From: Contact Centre (CRM) <contact@ribblevalley.gov.uk>
Sent: 26 November 2022 15:06
To: Planning
Subject: Planning Application Comments - 3/2022/1039 FS-Case-467981112

Planning Application Reference No.: 3/2022/1039

Address of Development: Land Adjacent to 115 Kemple View, Clutheroe, BB7 2QJ

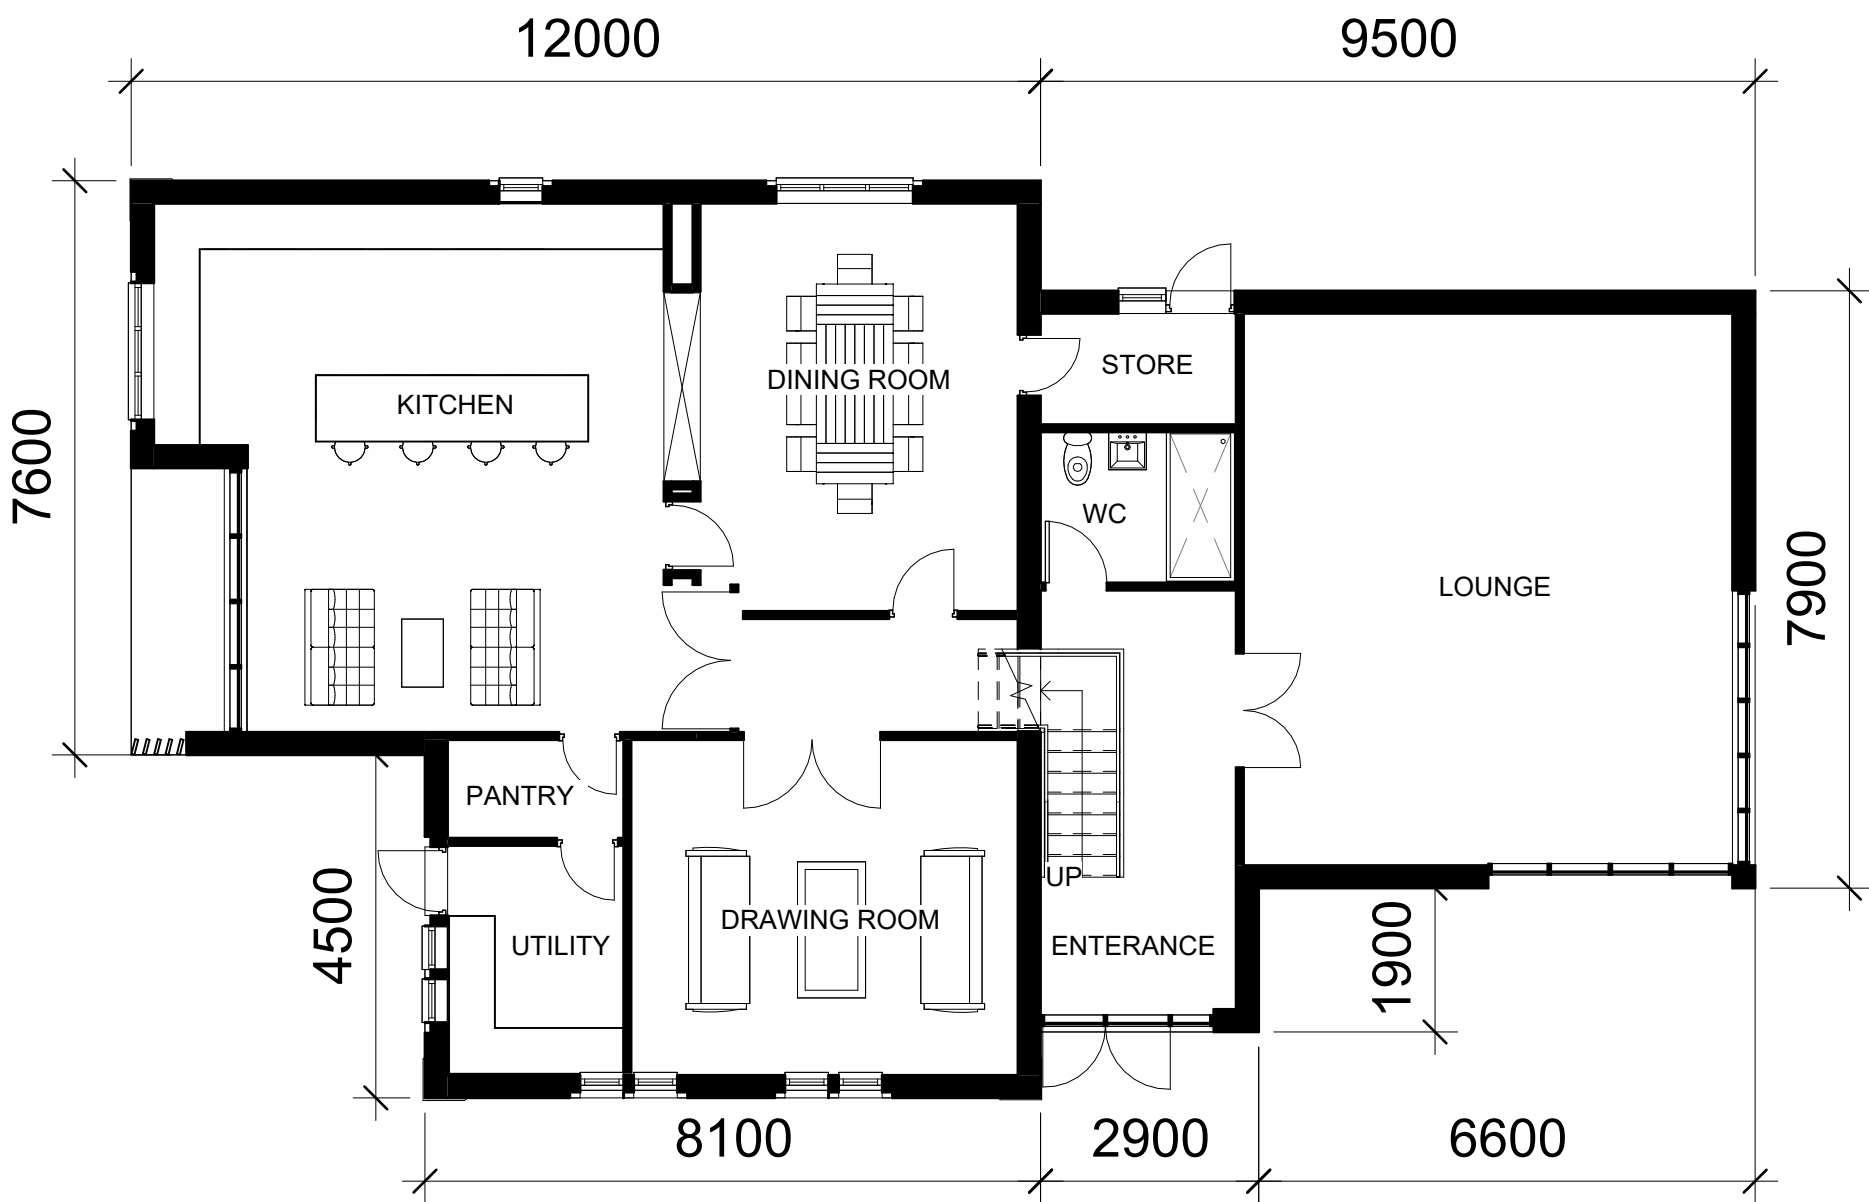
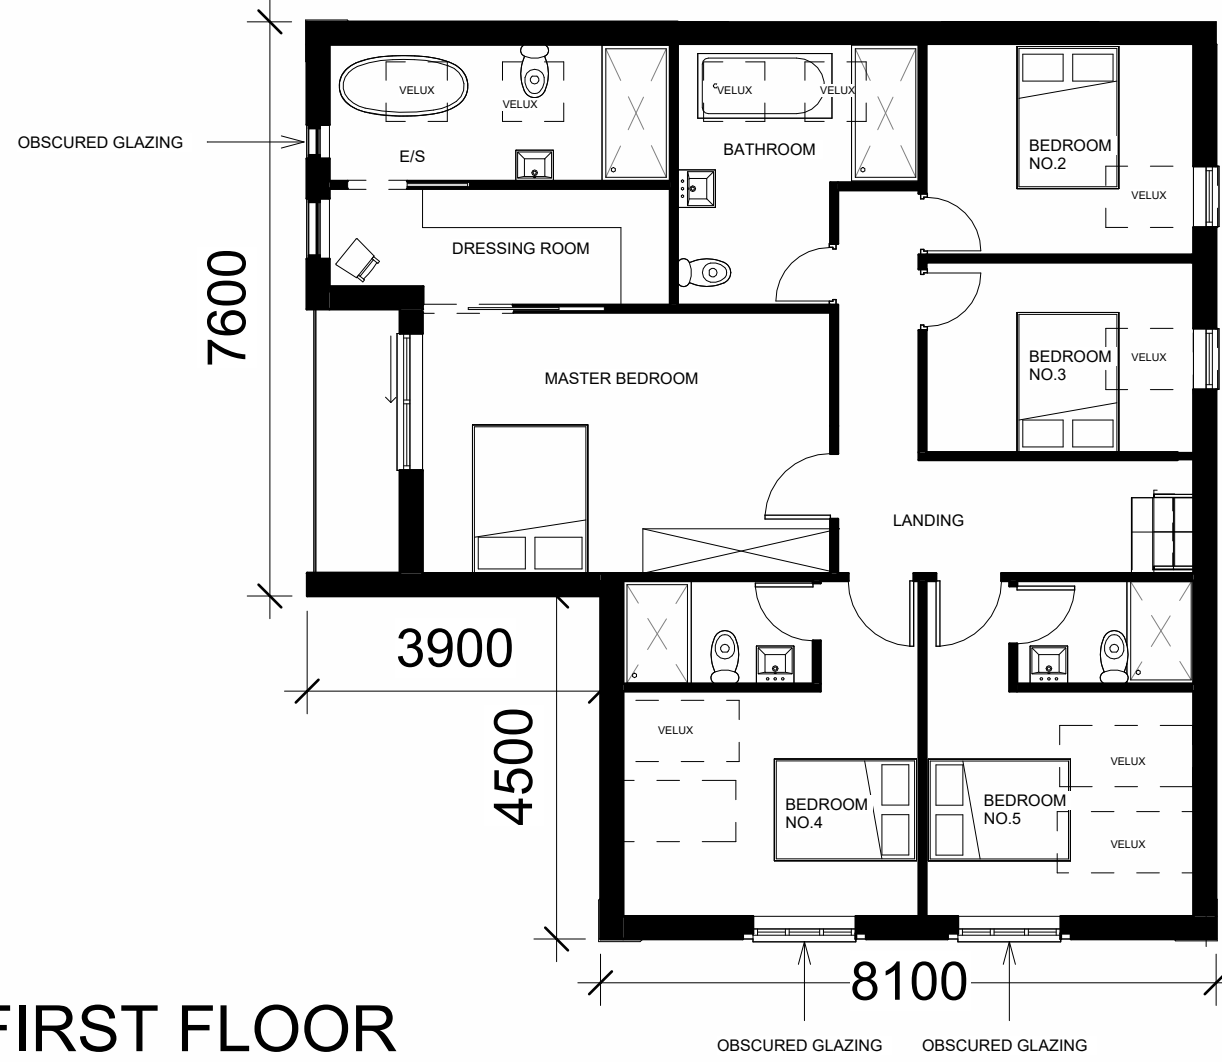
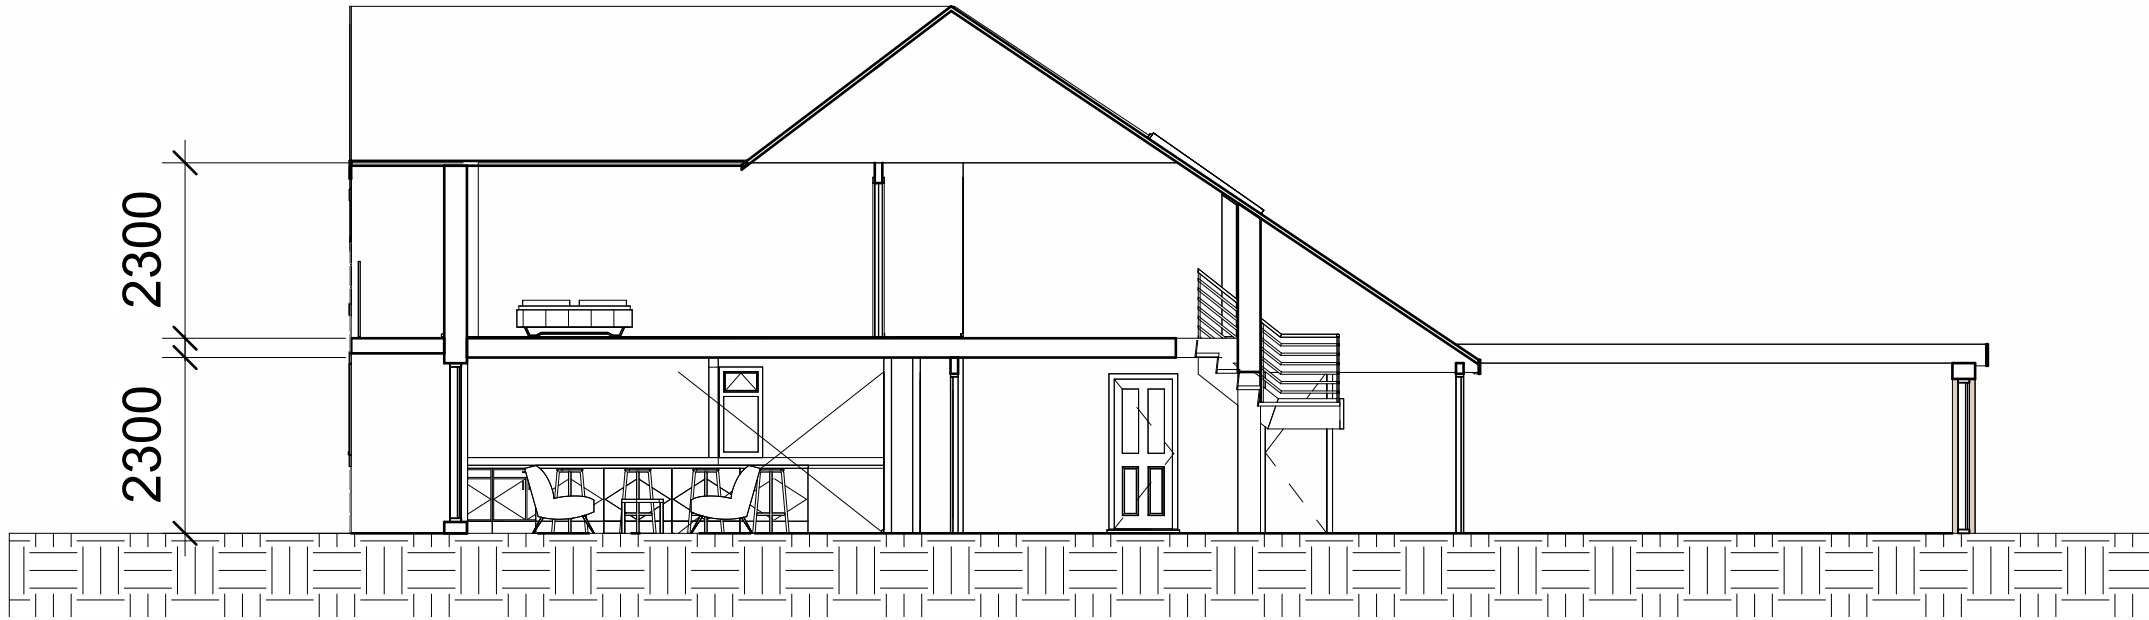
I would like to reject the plans for building the 2 very large structures on the land adjacent to 115 Kemple View. These large houses are not in keeping with the surrounding homes and will be an eyesore for the local and established houses in this area.

1 PROPOSED SITE PLAN 1
1 : 200

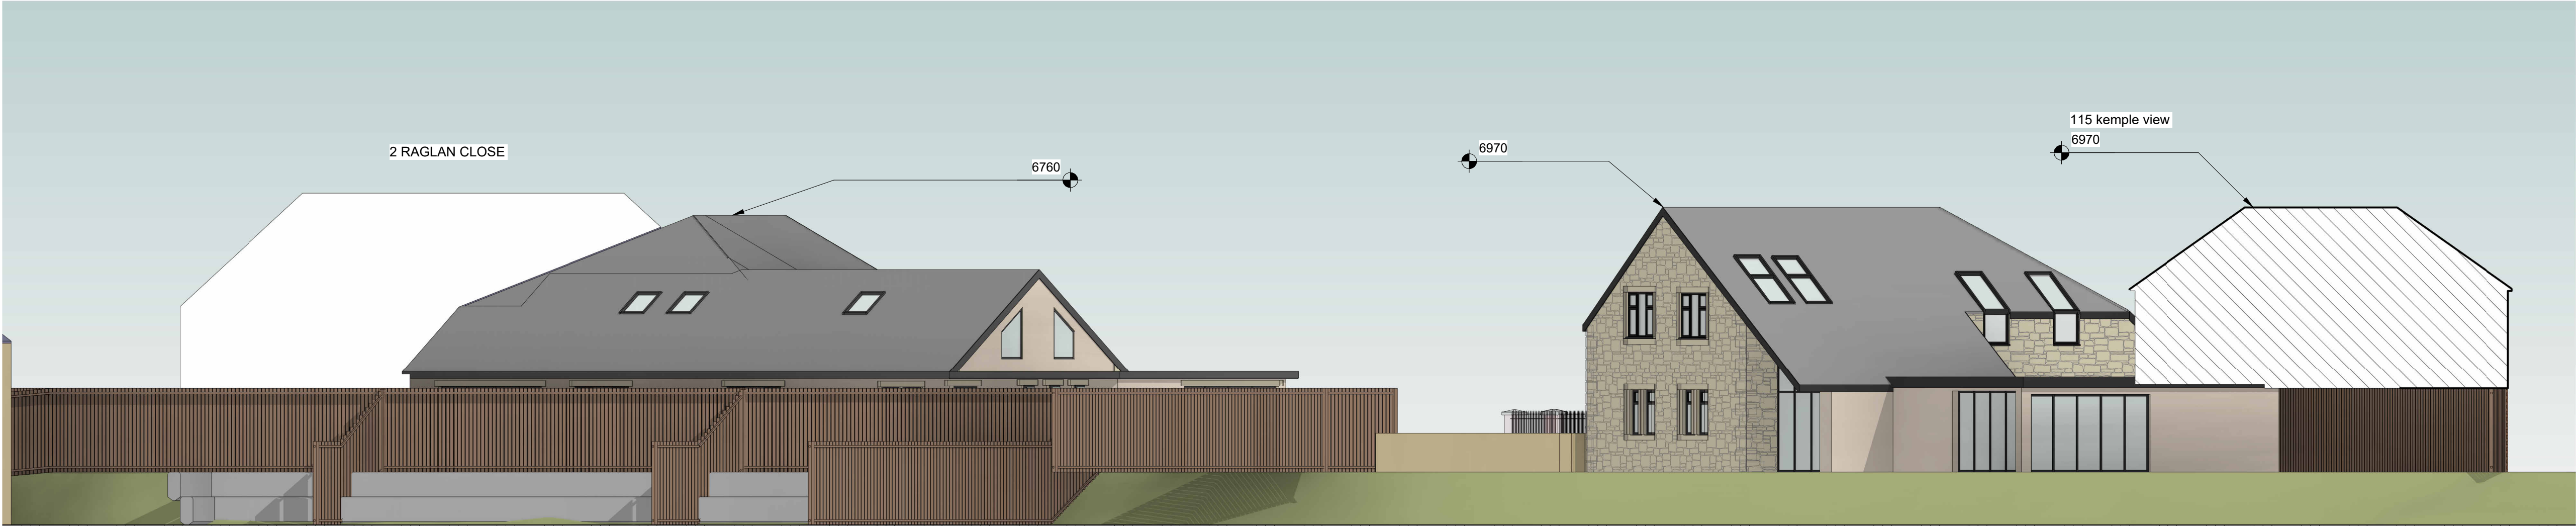
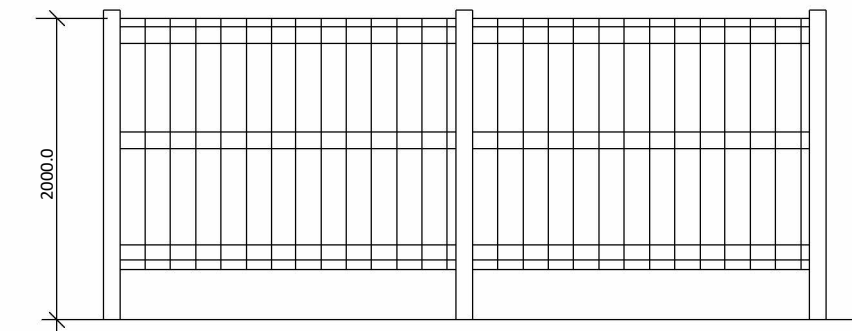
The plans seem to be missing a rather large tree that is on the shared driveway, is this to be cut down? The plan also shows no trees at the back of the property, are these also being removed?

Finally these don't look much like homes, rather meeting places, the amount of car parking spaces demonstrates this, there is an excessive amount of spaces per structure, thus telling me they are to be used for something other than homes.
